# Greenwich Community Association Inc

17 December 2019

## **State Significant Development SSD 8699 Redevelopment of Greenwich Hospital (Concept)**

DRAWING TITLE:
SITE ELEVATION & SECTIONS
DATE:
AUGUST 2019
DRAWN:
ML, JC
PROJ ARCH:
BF
SCALE:
As indicated @ A1
REVISION:
P5

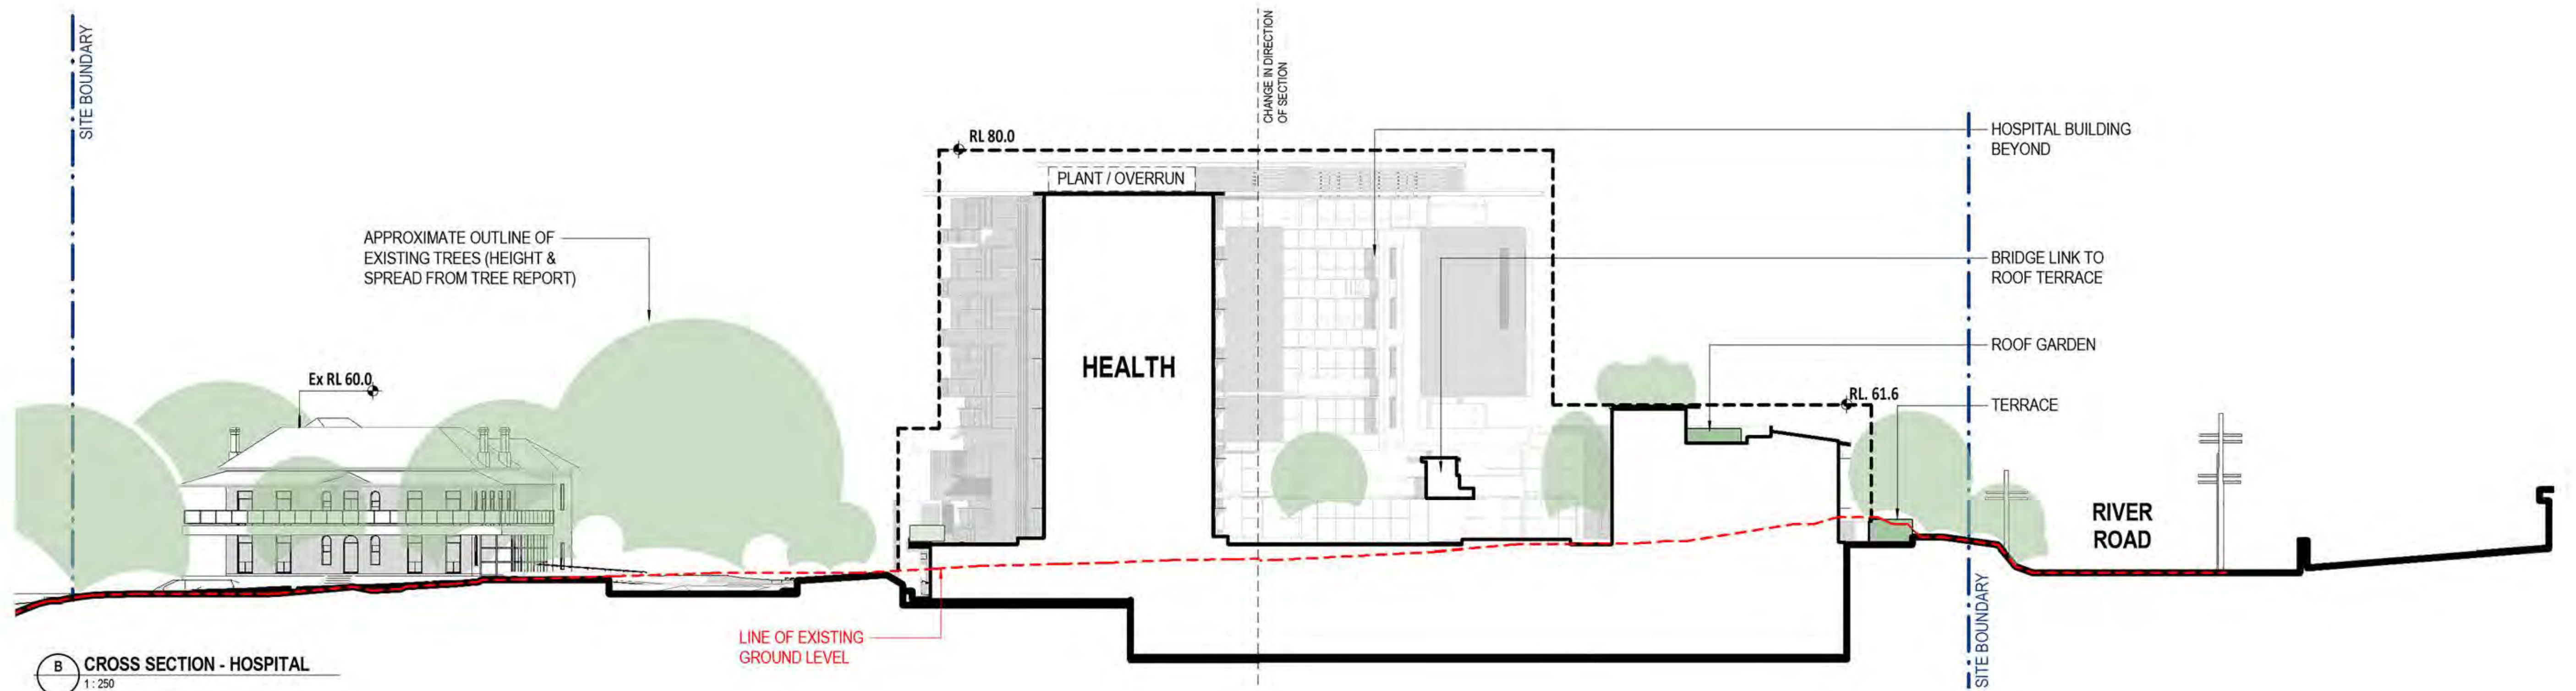
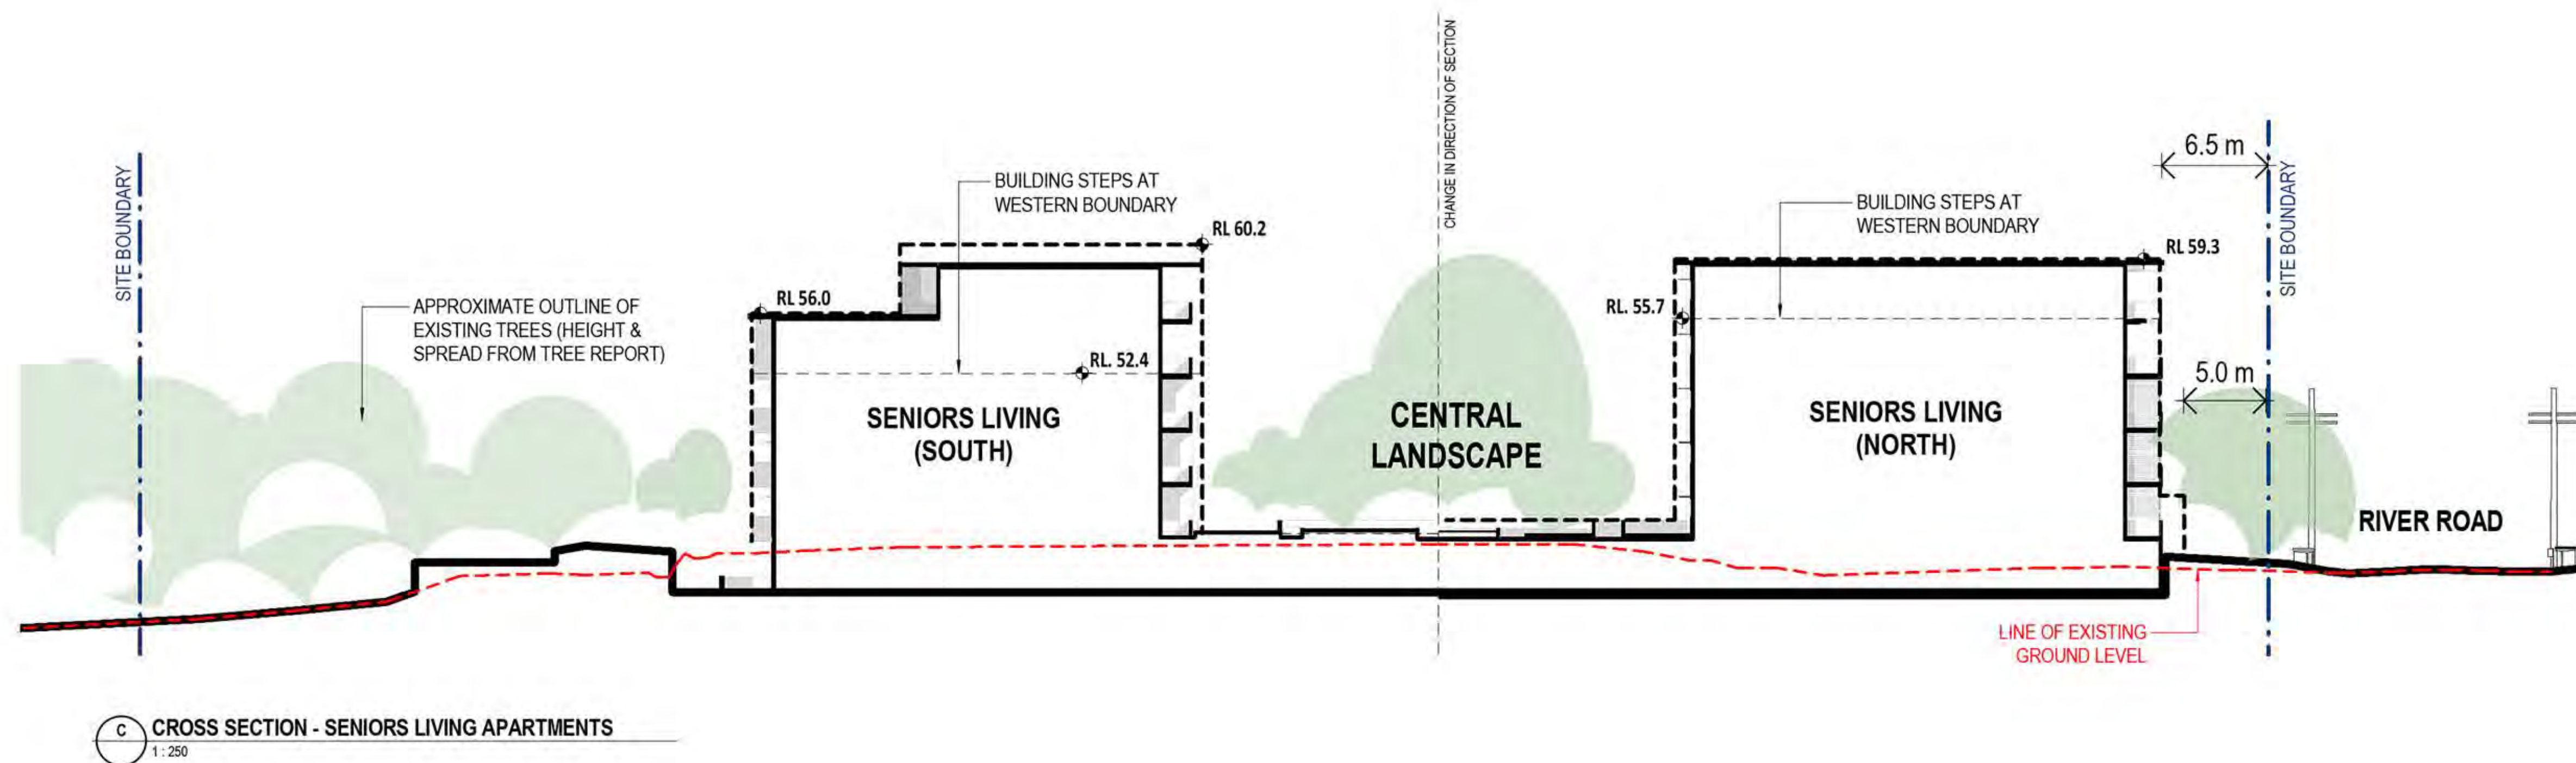
The proposed development will extend significantly above the trees and bushland that form the backdrop to Bob Campbell Oval. The height and presentation of the building will dominate the bushland setting – the development is completely out of character with the residential developments along the ridge above Bob Campbell Oval that all blend with their bushland setting.

**The design of the proposed apartment building on the southern boundary is inconsistent with Objective H1.5 of the Lane Cove Development Control Plan and should be revised.**

DRAWING TITLE: EXISTING TREES		DATE: AUGUST 2019		DRAWN: EC		PROJ ARCH: BF		SCALE: 1: 500 @ A1	
				PROJ: 1213		DRAWING: S.10		REVISION: P5

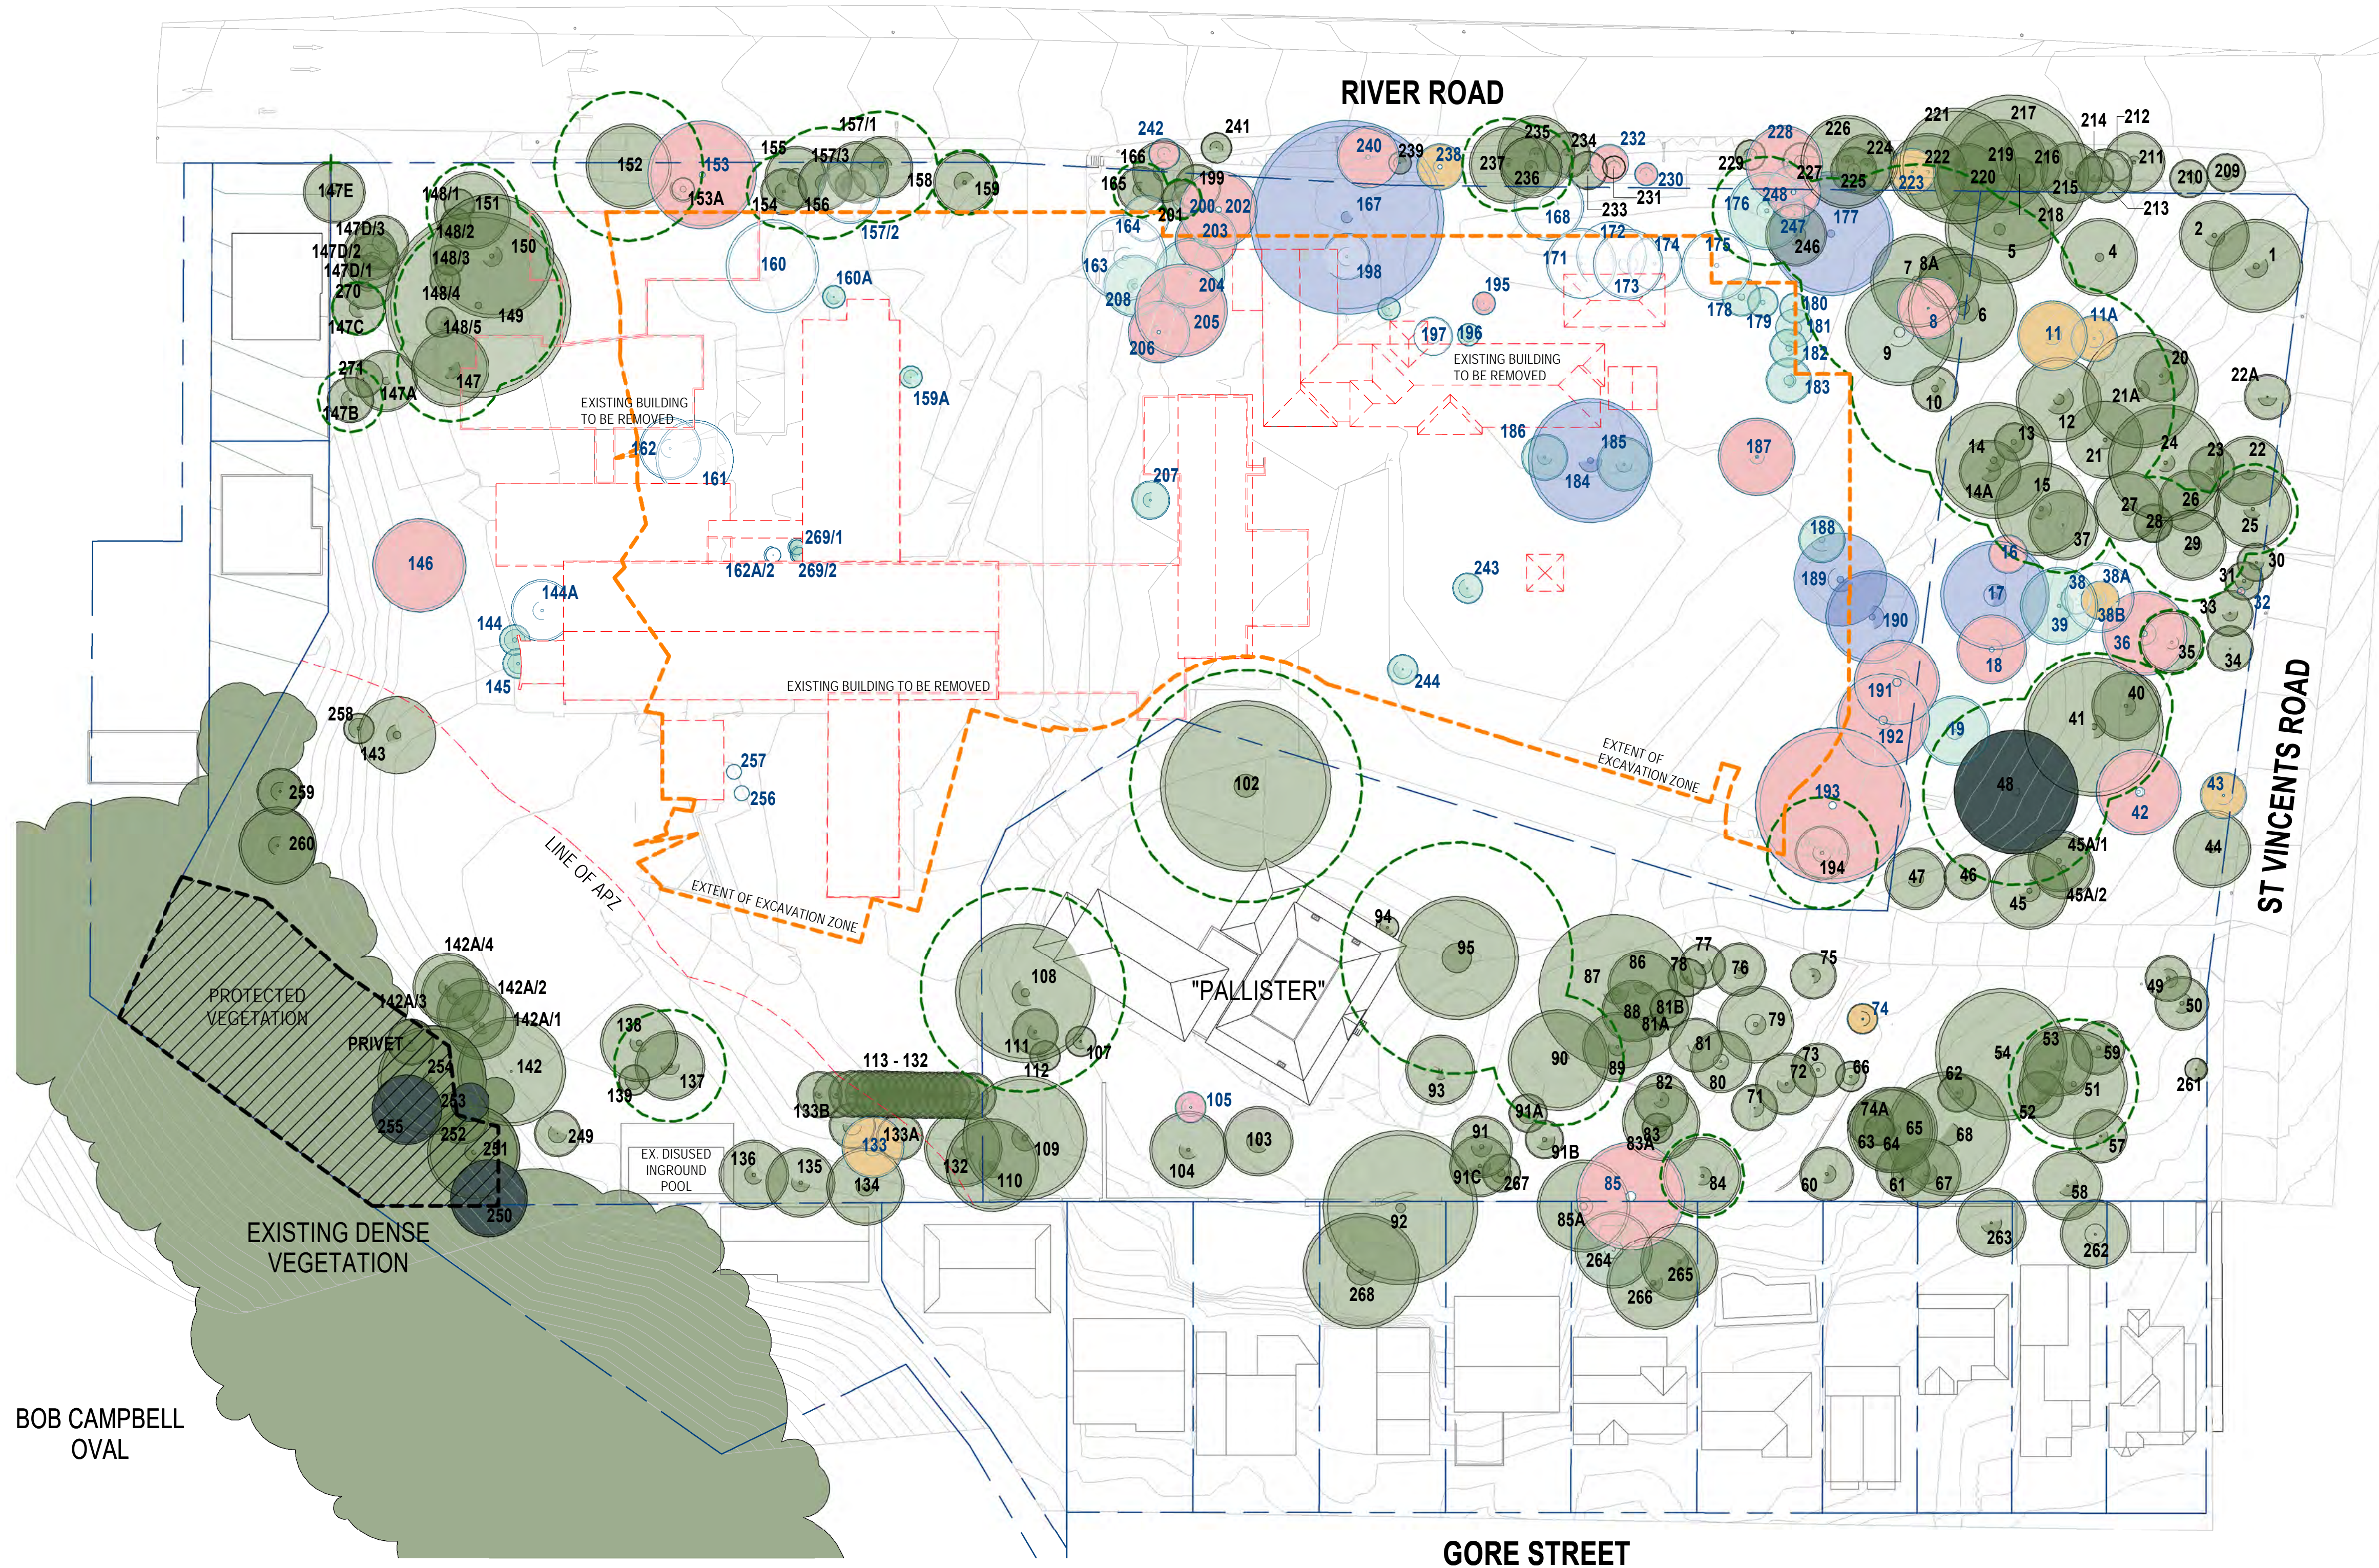
The construction of the proposed apartments will require significant mature tree loss with little opportunity for replacement planting, given the extent of hard surfaces proposed around the perimeter of the apartments.

The construction of the villas will require removal of a large number of mature trees. These trees enhance the significance of Pallister House.

**The proposal should be reviewed to minimise tree loss and to ensure that the curtilage around Pallister House is consistent with its heritage significance.**
